Application No: R/197/20/OUT
Site Address: Croft Works 52 Mill Lane Rustington BN16 3JN
Description of works: Outline application with some matters reserved for the demolition of existing dilapidated storage buildings & erection of 2 No. detached 3-bedroom chalet bungalows with associated car barns, gardens, car parking & landscaping (resubmission following R/117/20/OUT).

Thank you for your internet representation made on 26th October 2020 which has been recorded as an objection with the comments as follows:

SITE PLAN 1:250

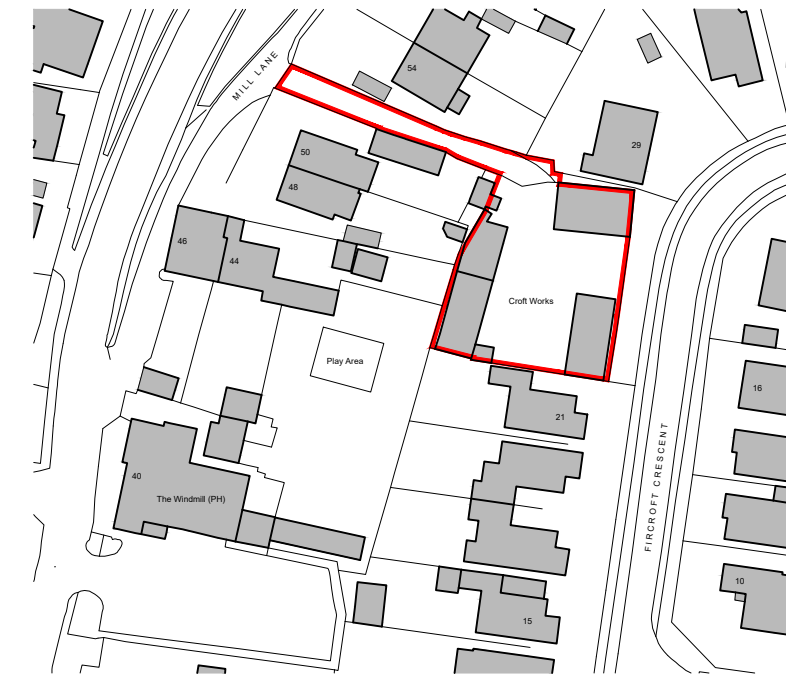
The first and main point of concern is that the highlighted red boundary enters our property boundary (number 48) which is detailed within our deeds.

The architecture decision response states that there is assurance that a fire engine vehicle will be able to access the dwellings in accordance with building regulations. However, the turning point to enter the dwellings is restricted for both emergency and heavy plant vehicles.

The access to the private narrow lane is restrictive of movement for vehicles entering and leaving.

There is an alternative way to access the proposed dwellings via Fircroft Crescent which is wider and would not impact access and the maintenance for the surrounding residents.
